**West Wallsend Colliery Modification 1 (MP 09_203 Mod 1)
Proposed Modification**

West Wallsend Colliery Modification 1 (MP 09_203 Mod 1) General Comments and Recommendations NSW Office of Water

West Wallsend Colliery Modification 1 (MP 09_203 Mod 1)
Office of Water assessment of the West Wallsend Colliery
Longwalls 51 & 52 proposal against the AQUIFER INTERFERENCE POLICY (AIP)

FIGURE 1.3
Conceptual Layout for Proposed
Longwall Panels 51 and 52

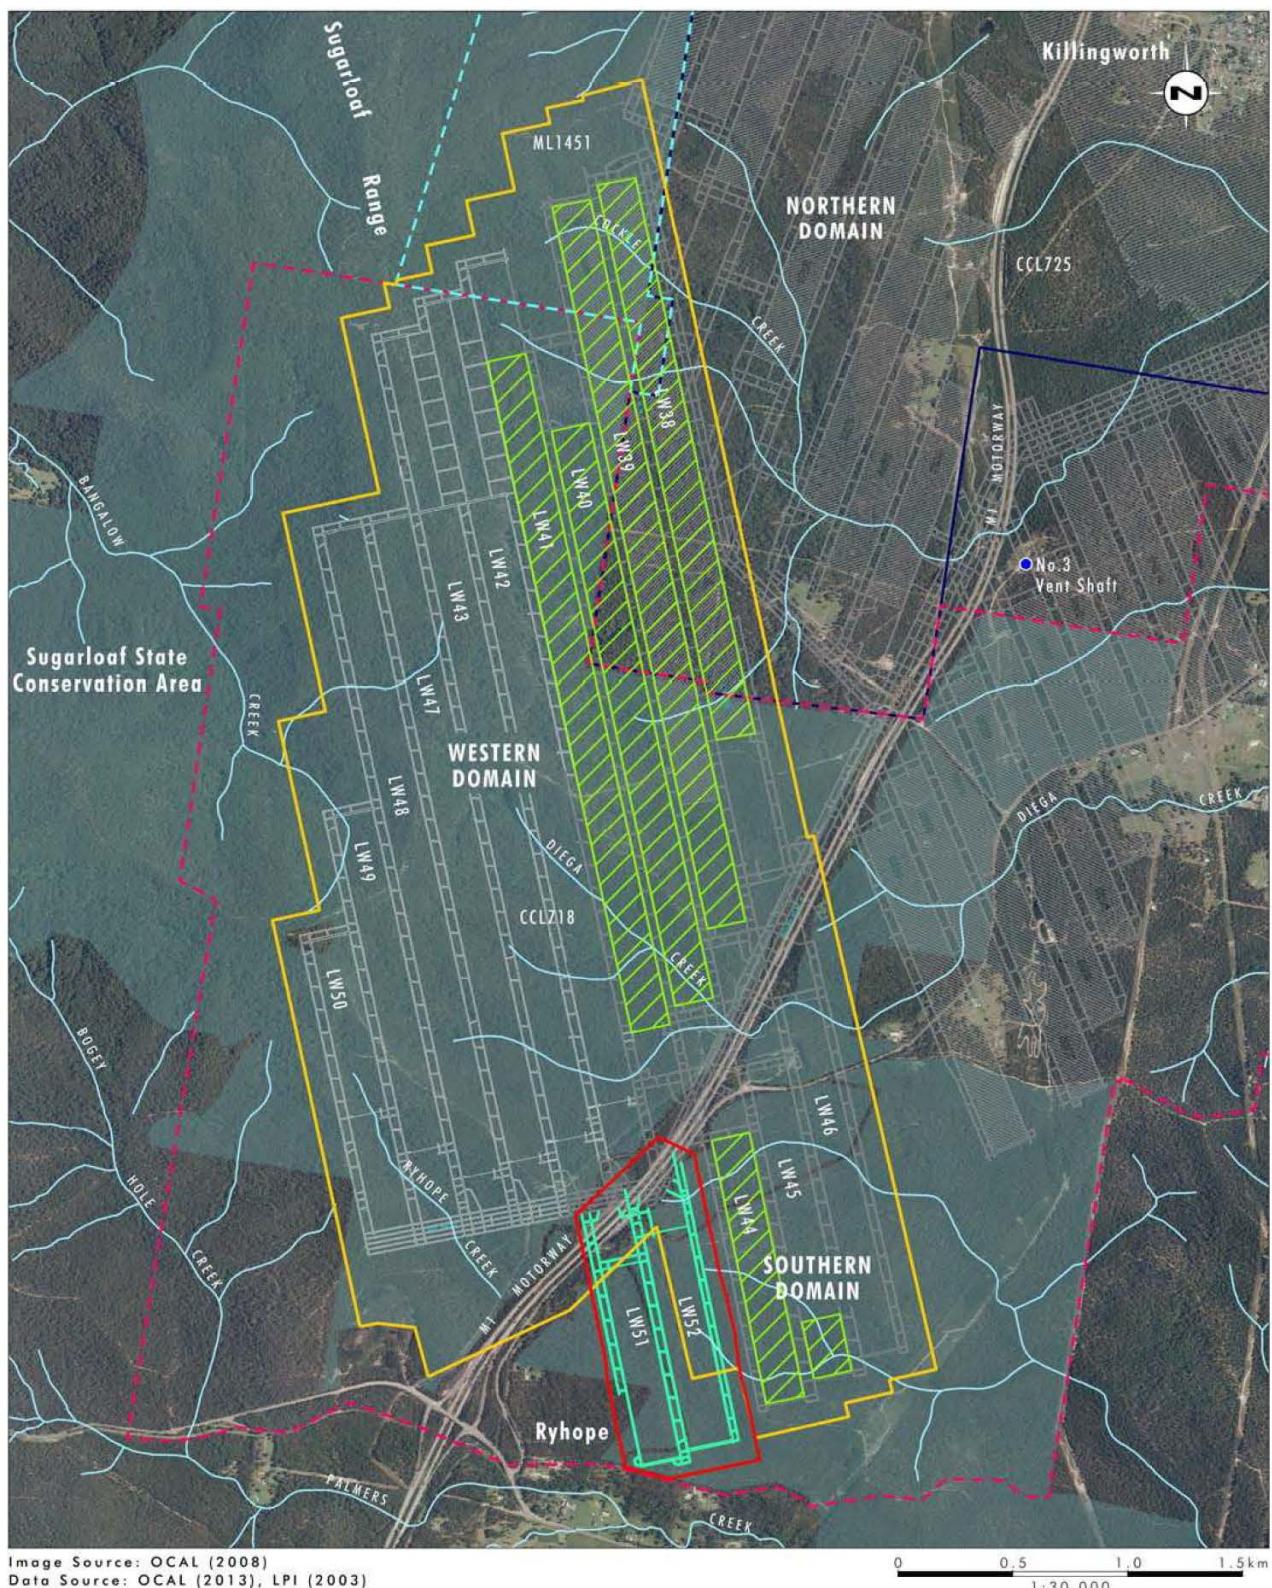
The likely expression of subsidence at WWC of LW 51 and LW 52 blocks needs to be predicted based on the level of strain concentration within the stream channel and its surrounding bedrock, and the variation of extraction height which is proposed by WWC, on the recommendation of Ditton Geotechnical Services. Neither survey data relating to the depth of incision of the Palmers Creek headwaters, nor the reduced extraction height proposed by WWC has been presented in the materials provided, so comments will be limited to comparison to full height extraction, especially in Diega Creek, located to the north of Palmers Creek, which was undermined by WWC in 1999-2002.

The two 1st order headwaters to Palmers Creek may be affected by mining subsidence. This may involve downward propagating surface fracturing. The risk of inter-connective fracturing from surface to the mine workings cannot be specifically assessed, based on the lack of data provided. However, avoidance of inter-connective fracture development appears to be a commitment of WWC, based on comments in s 6.2.4.1. This should be a specific requirement of any approval to mine in the vicinity of the headwaters to Palmers Creek.

where extraction height is reduced beneath watercourses. However, specific comments cannot be provided without further explanation as to the modification of mining and extraction height near the Palmers Creek headwaters.

4. Clarification is required regarding the proposed protection measures for the headwaters of Palmers Creek, including reductions in extraction height in LW 51/52.

1. A survey plan and monitoring program must be devised which will enable medium term monitoring verification of predicted subsidence resulting from longwall extraction. This should include pre- and post- photographic records of channel widths, sand infill and bedrock exposures which may be affected by changed long profile gradients or fractures. Surface fracture propagation should be minimised, and remediated if detected in the watercourse. Remediation may include hand grouting surface cracks should identified flows in the watercourse be lost, or become contaminated within the basal fracture network. Should levels decline (ie by slumping or headcut initiation), woody debris may be used to form debris barriers or lateral sills (keyed into both banks) installed to prevent headward migration of incision or development of headcuts.

FIGURE 6.11
Alluvial Areas

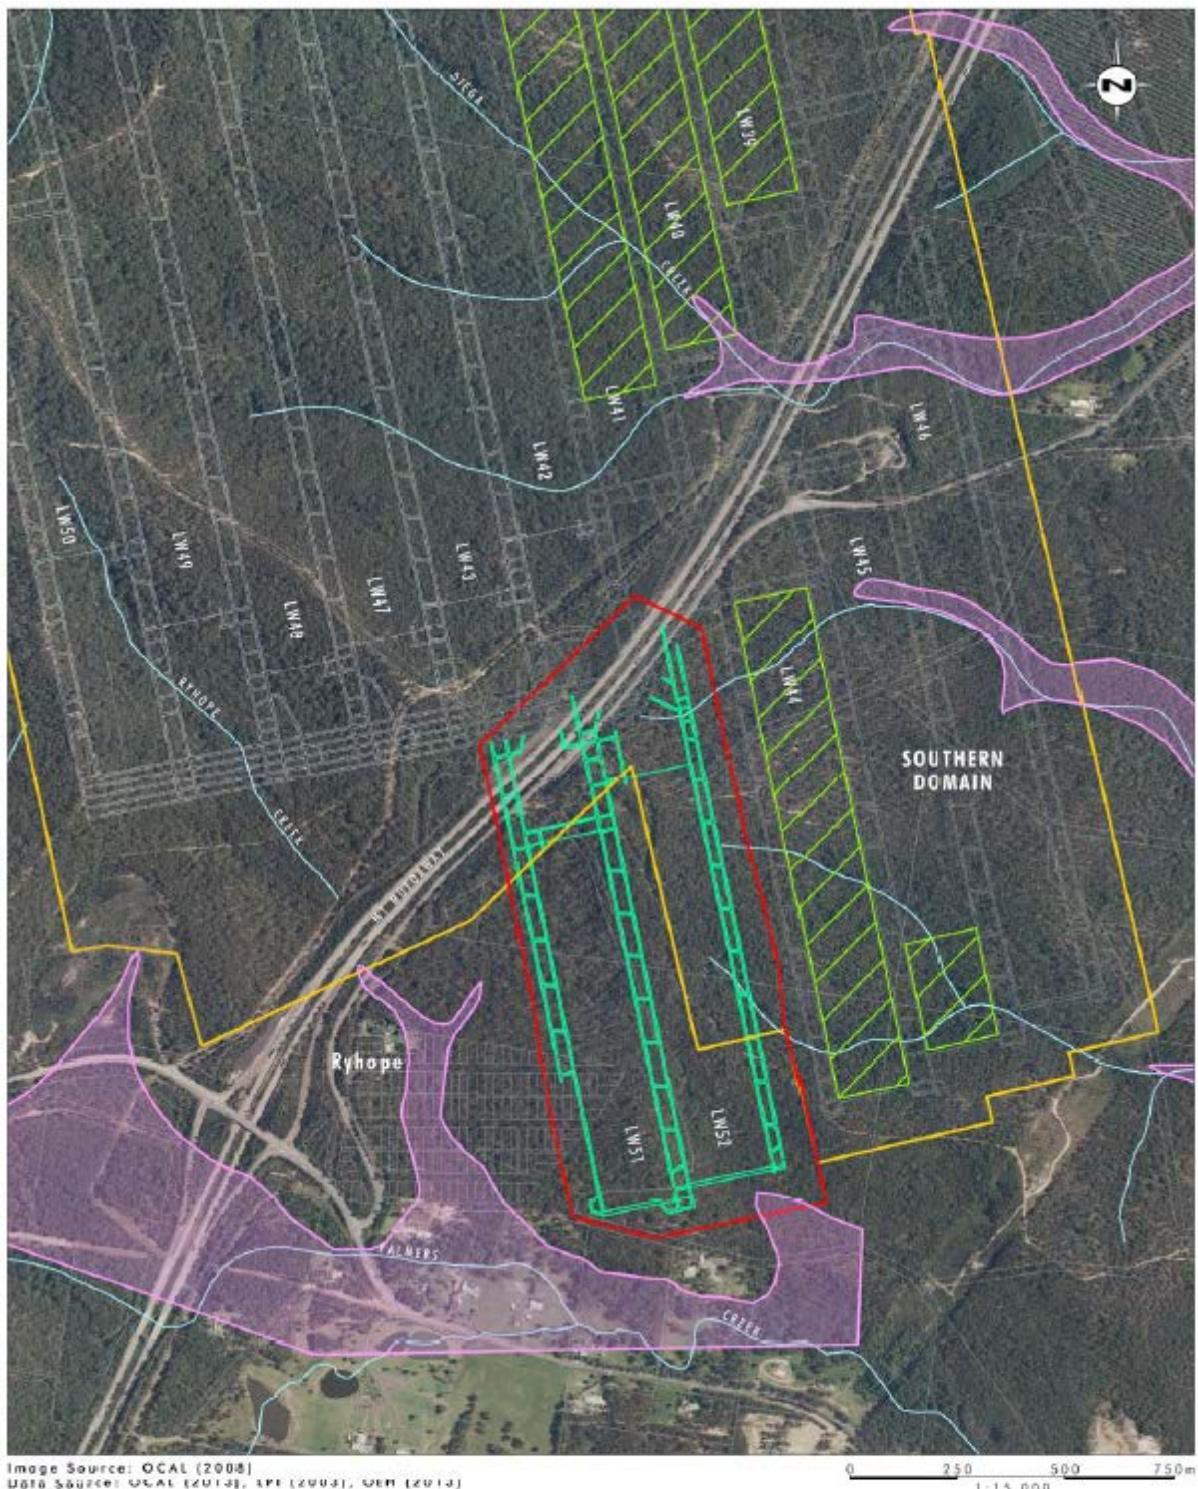
Two first order watercourses cross the longwall footprint, and will be within the subsidence trough (goafed surface) once longwall extraction occurs. One of the two first order minor watercourses crosses the M1 motorway immediately north of the Bushrock Rd entrance to Wakefield Rd, which has two culvert controls on the residential road forming part of Bushrock Rd and Wakefield Rd, downstream of the large box culvert crossing by the twin carriageways of the M1 motorway. The other crosses under Wakefield Rd and the M1 motorway by culvert crossings north of the end line of the longwall blocks.

A hillslope stock dam, located about 100 m west of the 2nd order arm of the Palmers Ck headwater, is 300m outside the longwall footprint. The 2nd order section of the Palmers Creek headwater is aligned along the base of the proposed longwall subsidence trough, forming outside the subsided zone. The watercourses, as described above, have not been specifically inspected. However, they are comparable to upper headwater sections of Diega and Cockle Creeks located on the project site, which have been previously inspected prior to, and following, longwall subsidence.

The two additional longwall panels are positioned outside the alluvial boundaries which would likely limit the amount of water take from the North Lake Macquarie Water Source and limit impacts on water users. However, the Groundwater Impact Assessment (GIA) undertaken by the proponent was done without a groundwater model and has primarily relied upon interpretation of impacts based on the potential extent of goaf fracturing. This methodology is insufficient to provide the information that would adequately address the Aquifer Interference Policy requirements.
